## ASSESSMENT REPORT

### Gwandalan Residential Subdivision, Gwandalan 10\_0205 MOD 3

Figure 3: Gwandalan Development Control Plan Subdivision Staging Plan.

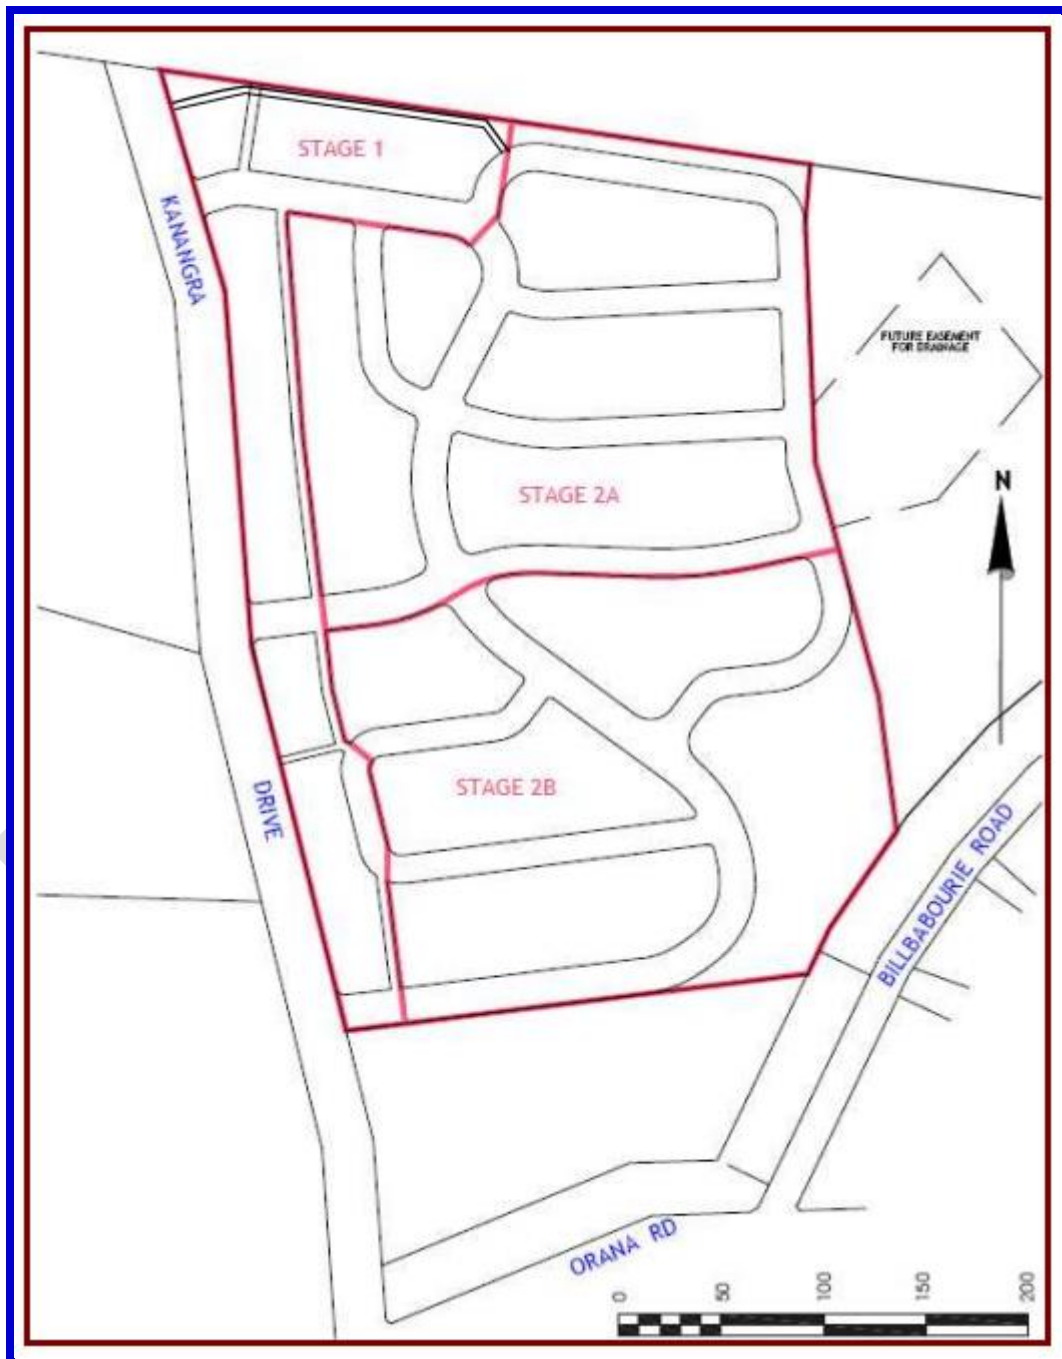
The updated subdivision staging plan is inconsistent with the original subdivision staging plan for the site provided by the Gwandalan Development Control Plan (Gwandalan DCP) as part of 10\_0205 (see **Figure 3**). Notwithstanding this inconsistency, the Department considers the updated subdivision staging plan to be acceptable. The Gwandalan DCP's subdivision staging plan has previously been varied by 10\_0205 MOD 1 (see **Figure 4**). Furthermore, the subdivision is at an advanced stage of development with most of the subdivision stages either complete or nearing completion as of July 2018 (see **Figure 7**).

Figure 5: Proposed Subdivision Staging Plan.

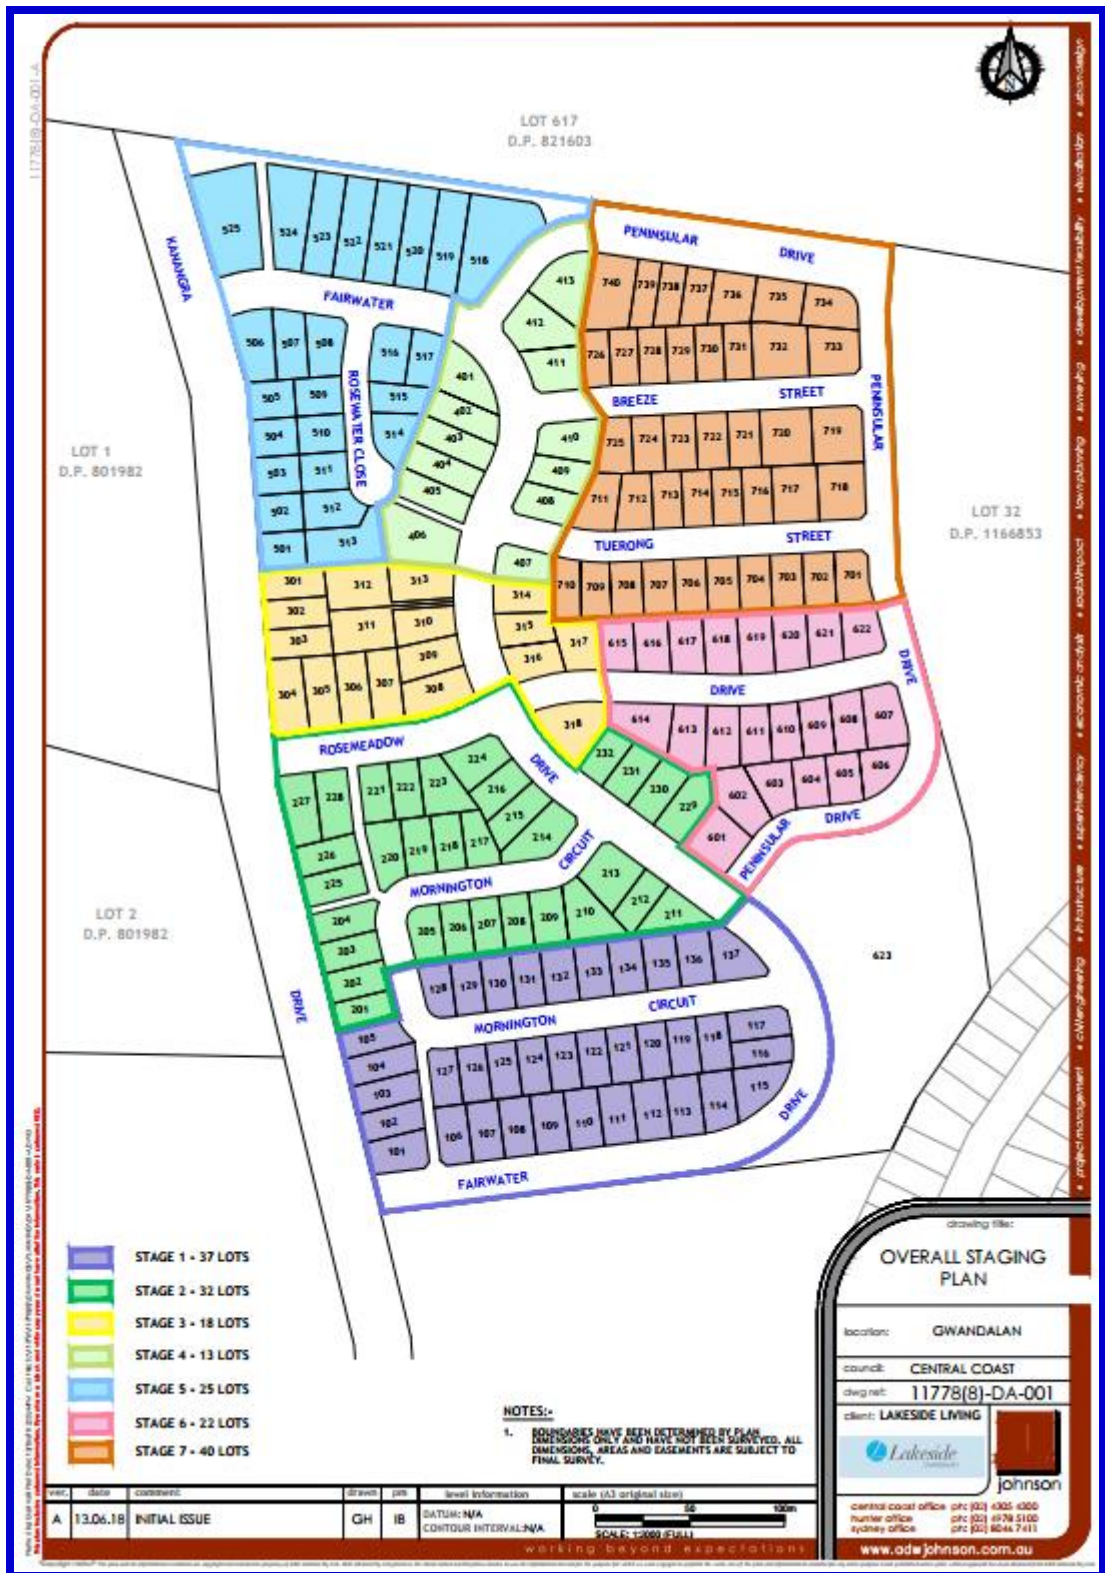
The application seeks approval for an updated subdivision staging plan (see **Figure 5**). The staging plan will maintain seven subdivision stages as currently approved but will reconfigure the sequencing of and boundaries between the stages. The modification is requested on the basis that the updated subdivision staging will reflect minor boundary changes approved by Central Coast Council as part of the construction certificate process.

The remaining stage to be developed under the updated subdivision staging plan (stage 7) corresponds with the last stage to be developed on the site. On this basis, the Department is satisfied that the changes to the staging plan are minor and acceptable.

Figure 6: Reconfigured Subdivision Lot Layout.

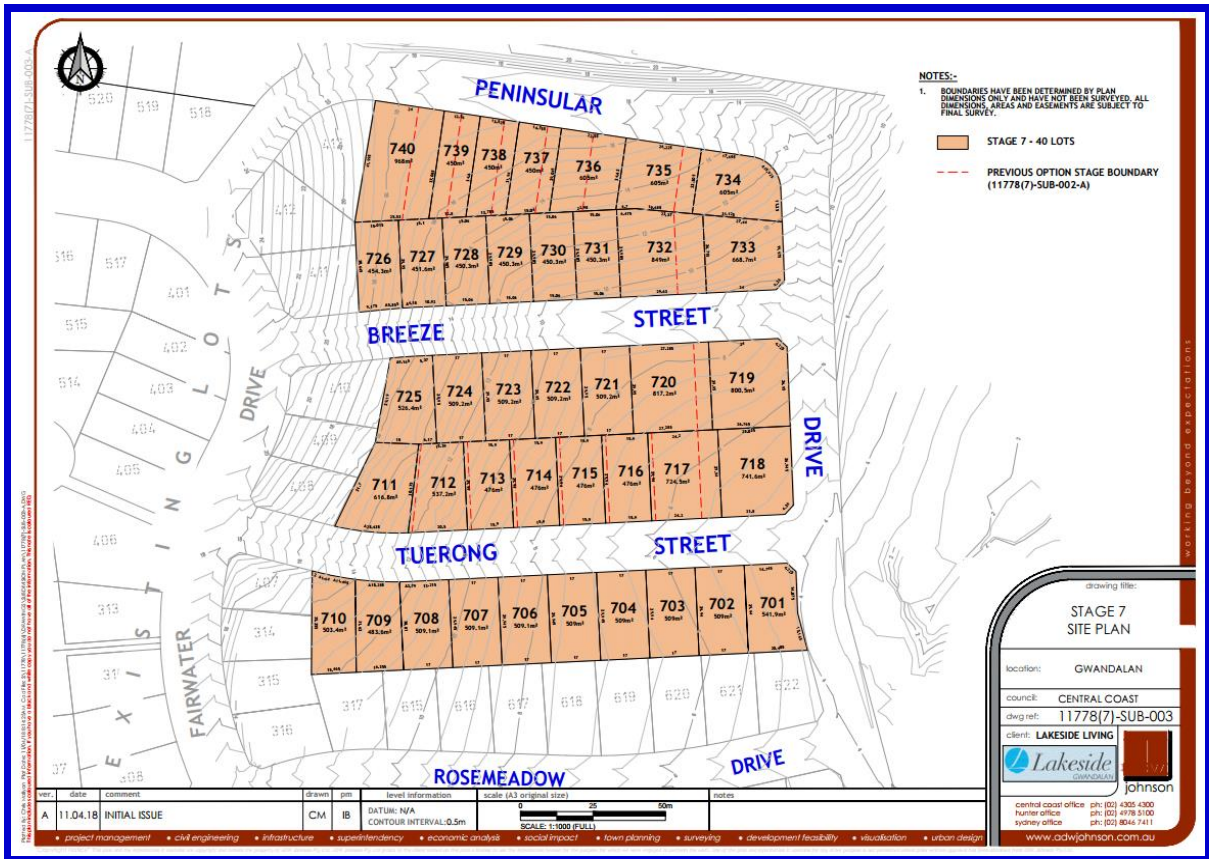
The Department notes the reconfigured subdivision layout is not fully compliant with the Wyong DCP.

The first variation relates to minimum lot frontages at the building line which the Wyong DCP requires to be 15m. Reconfigured lots 737, 738 and 739 will not comply with this requirement as they will have reduced lot frontages down to a minimum width of 12.56m. The Department is satisfied with this minor variation as it relates to only three lots, will add variety to the subdivision and the lots can easily accommodate detached residential dwellings.

The second variation relates to corner lot areas which the Wyong DCP requires to be 700m<sup>2</sup>. Reconfigured lots 733 and 734 will not comply with this requirement as they will have areas of 668.7m<sup>2</sup> and 605m<sup>2</sup> respectively. The Department is satisfied with this minor variation as it relates to only two lots and will provide corner lots with adequate areas to address dual frontage streetscape impacts, privacy issues, setback implications and intersection sight lines as identified by the Wyong DCP.

On this basis, the Department is satisfied that the reconfigured subdivision lot layout is acceptable as it will still result in appropriately sized and dimensioned residential lots that will be suitable for future residential housing.
